Subdivision Comments

From: Jesse Cox, Environmental Health Supervisor
Holly Erdman, Environmental Health Specialist

RE: SPF-21-00003 Colson

COLSON SHORT PLAT
 PART OF SECTION 10, T. 17 N., R. 20 E., W.M.
 KITTITAS COUNTY, WASHINGTON

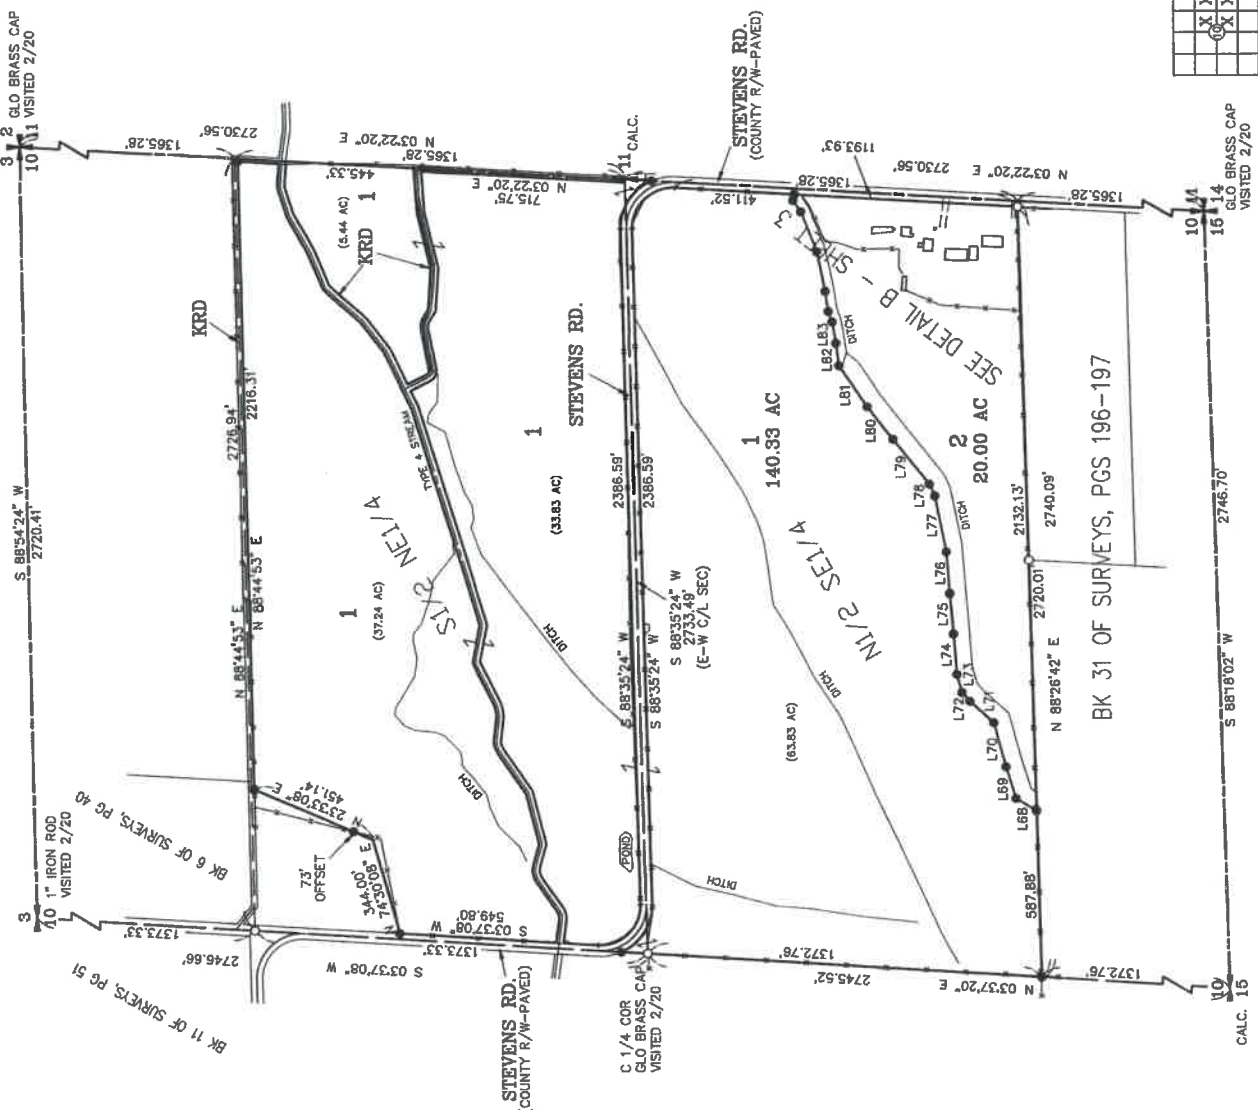
Proposed short plat indicates shared wells will be used. If the intention is to utilize a shared well at any time, a signed, notarized, and filed shared well users agreement will also need to be provided before short plat is finalized. All wells must meet setbacks required in Kittitas County Code prior to final approval. The applicant must prove legal and physical availability of water for all new uses of water on proposed lots.
